**DE-2025/70**

**SSD-73910208**

<b>Development</b>	State Significant Development – Seniors Housing – IRT Woonona Redevelopment (SSD-73910208) - Redevelopment of existing Seniors Housing development including the construction of five (5) apartment buildings containing independent living units, adaptive reuse of existing church, alterations/additions to existing Residential Care Facility, wellness hub, landscaping and car parking
<b>Location</b>	Retirement Village  2-8 Popes Road WOONONA NSW 2517

**Figure 30:** Proposed Floor and roof plan. Breath Architecture.

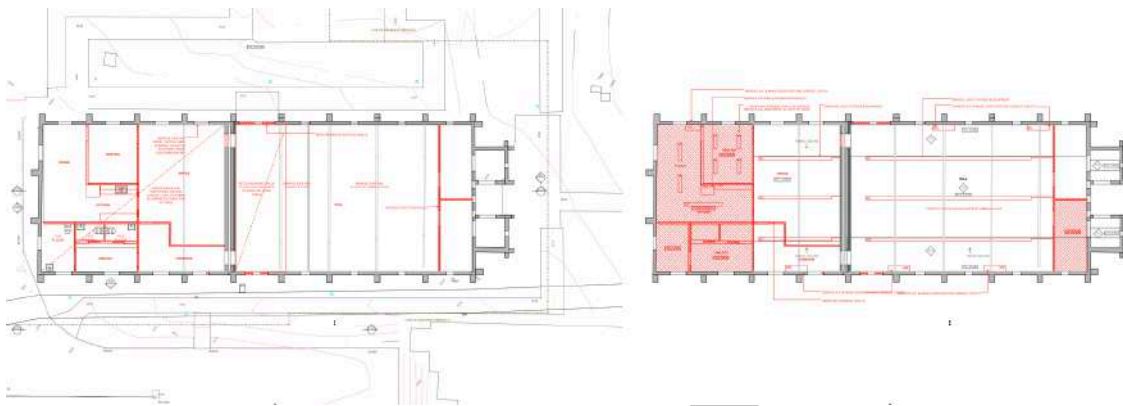
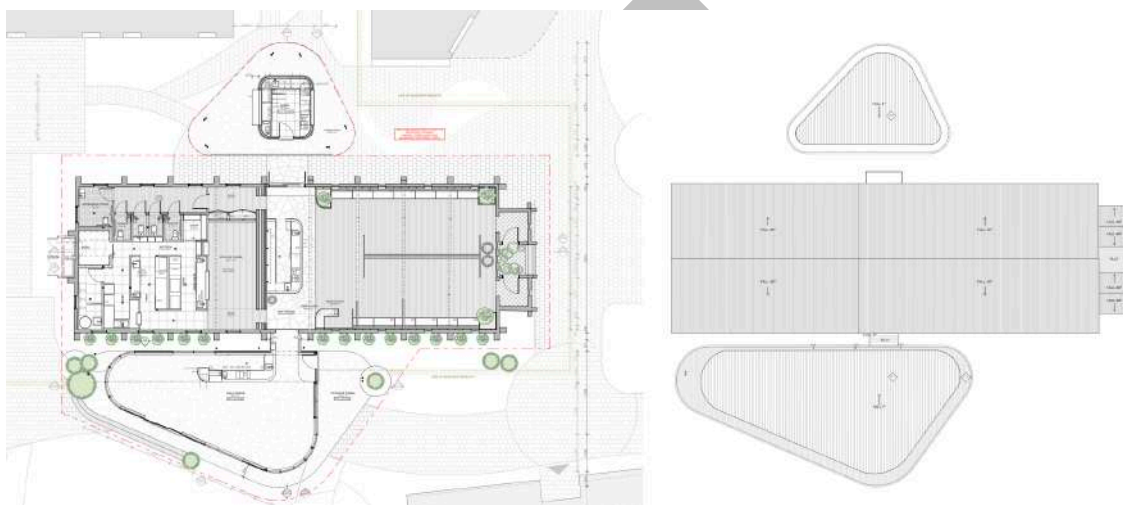
The additional buildings and pavilions proposed to connect to both the north and south side of the existing heritage church is questioned, particularly the cafe provided to the south. This disrupts view lines to the escarpment which is not supported. Refer also to comments under *Context and Neighbourhood Character*.

# Detail Area Drainage Channel

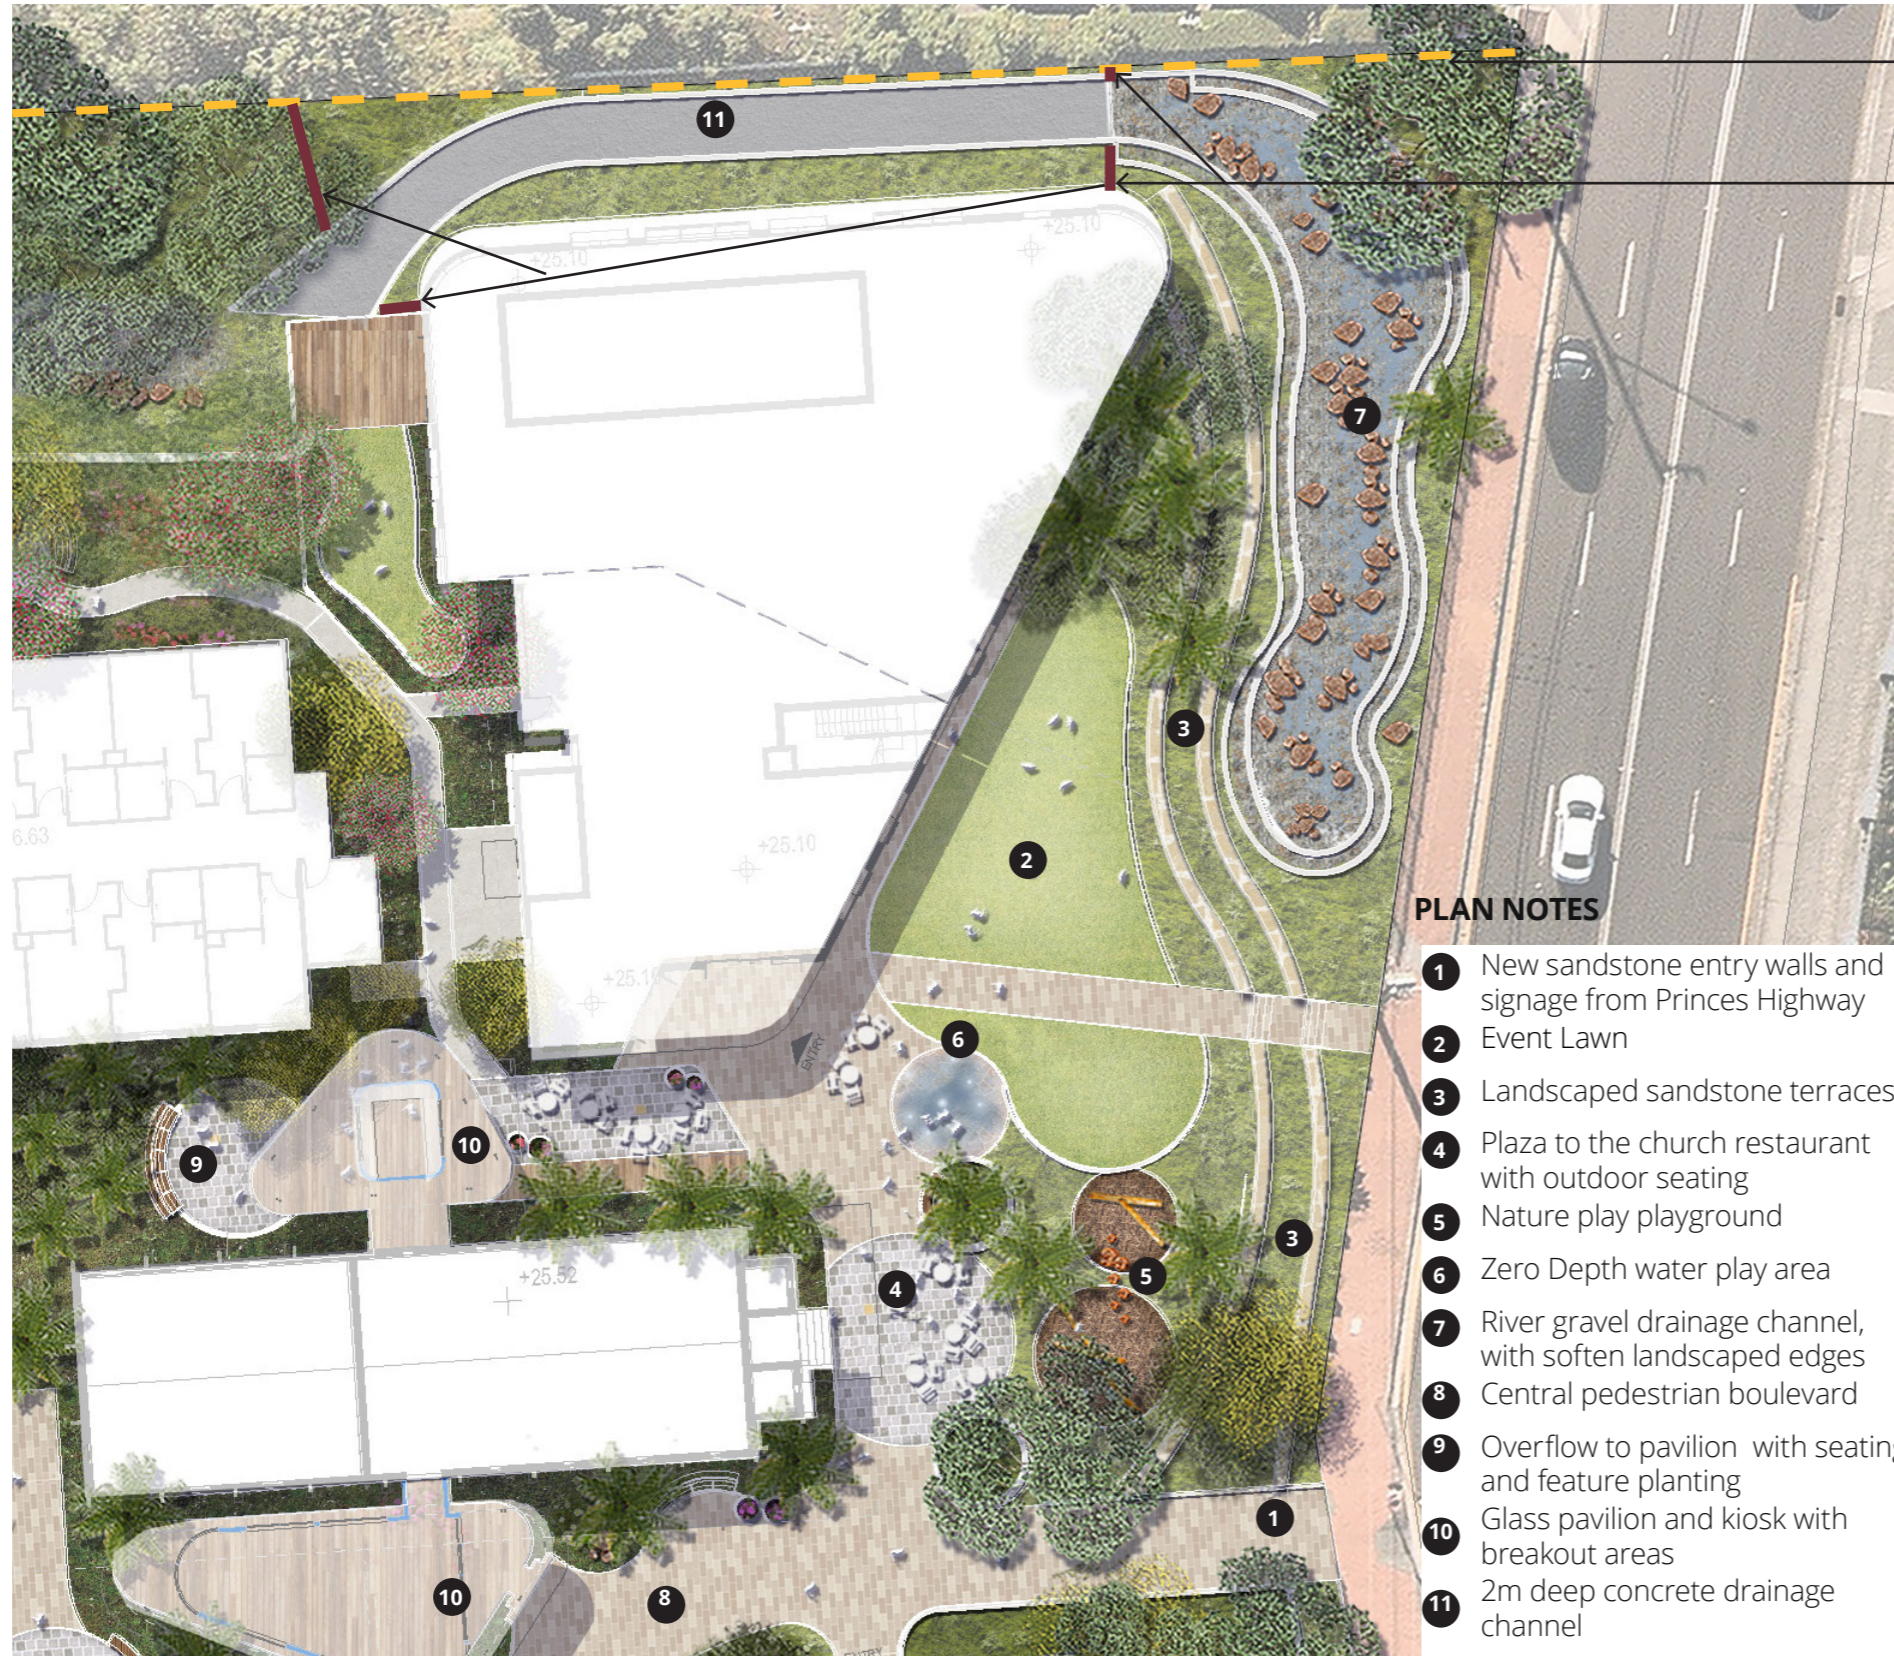
Ensure coordination between architectural, landscape and drainage/flood to accurately determine the visual impact of the drainage channel across various areas of the site. Detailed sections of the drainage channel in various locations are to be provided as part of the landscape documentation to ensure coordination has been undertaken and that it integrates well with the surrounding landscape design.

-  
An area of particular concern is that along the northern boundary of Building E. It should also be noted that whilst Section 2 on landscape drawing 5001 shows an acceptable landscape solution for the drainage channel, it is imperative that this has been coordinated with the stormwater and flood engineering to ensure the landscape vision can be achieved in its entirety.
